CITY OF ALBUQUERQUE

**Re: Winrock Redevelopment Dave and Busters
Erosion Sediment Control (ESC) Plan
Engineer's Stamp Date 2/11/2014 (J19/E038)**

Based upon your submittal received 2-19-14, the above referenced Erosion Sediment Control (ESC) plan is not acceptable based on the following comments:

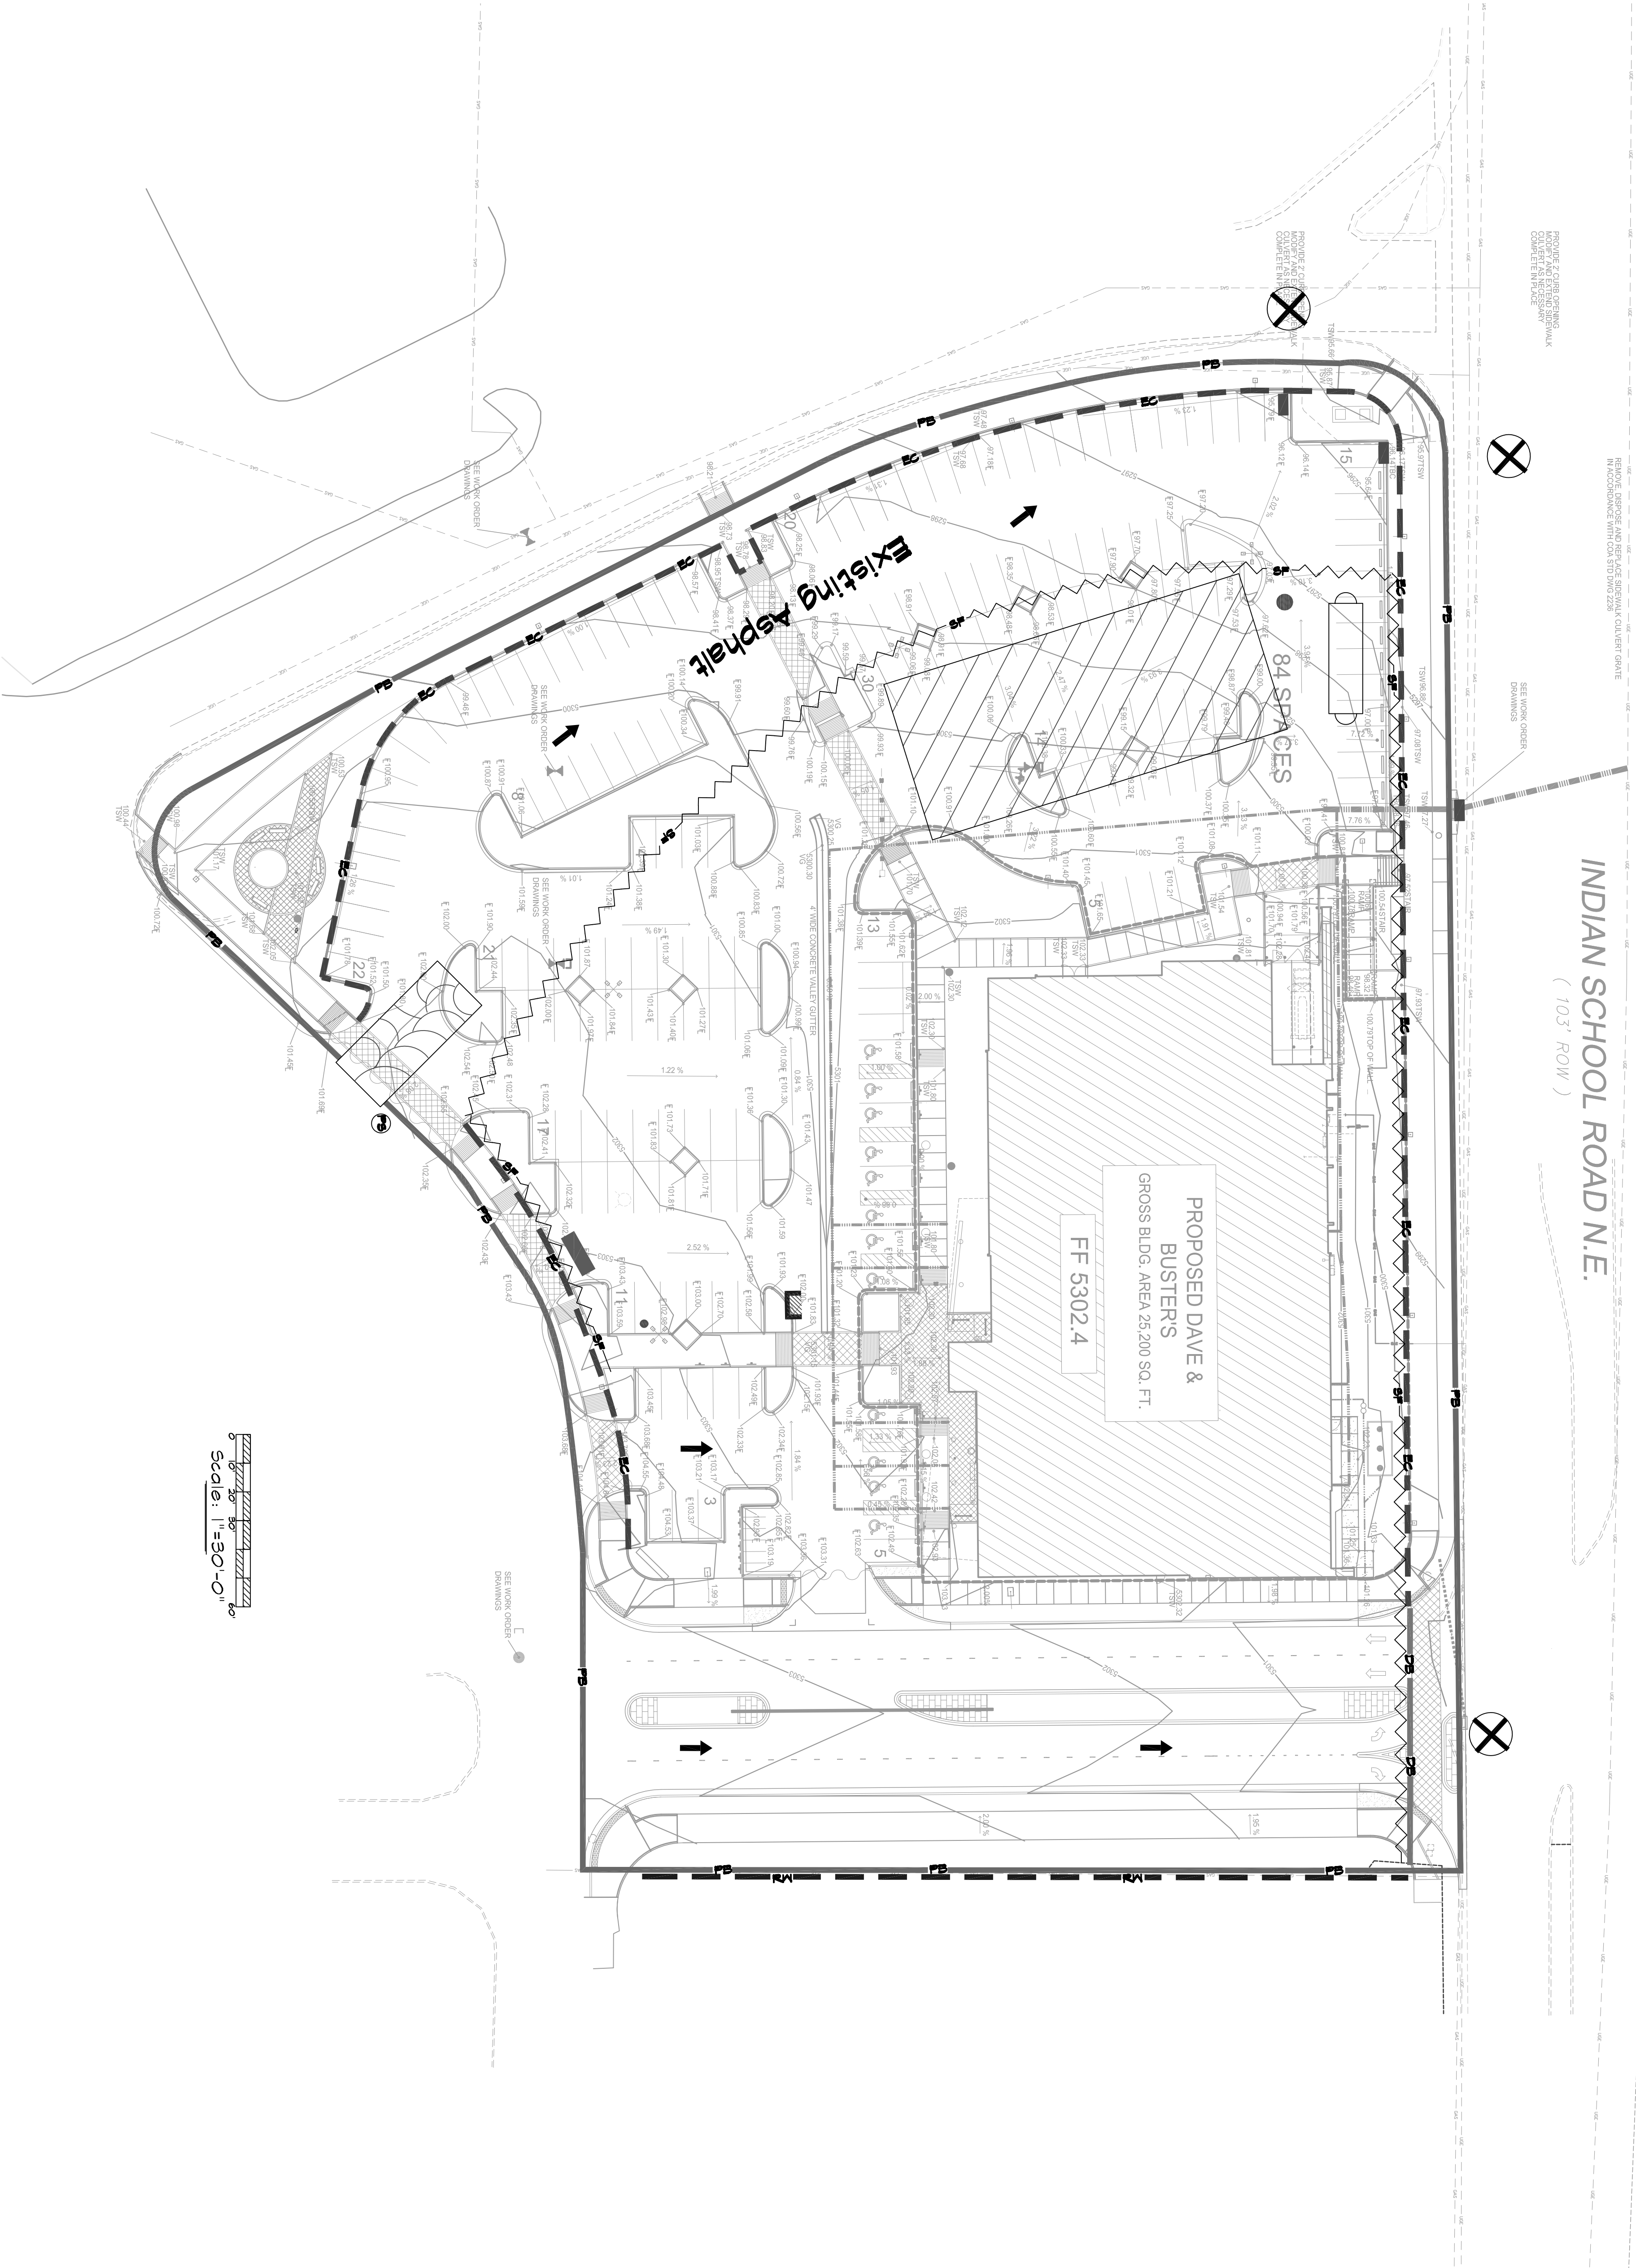
- An approved Grading and Drainage plan is required. Make all changes necessary to the ESC plan based on the approved Grading and Drainage plan.
- Provide scale of the drawing.
- Change the title of the plan to "Erosion and Sediment Control Plan".
- Show the NPDES Posting Board location. The board should be visible from public sidewalk or street.
- Provide a detail sheet for the BMPs.
- Remove all unnecessary notes and titles, and only show the necessary notes for the ESC plan.
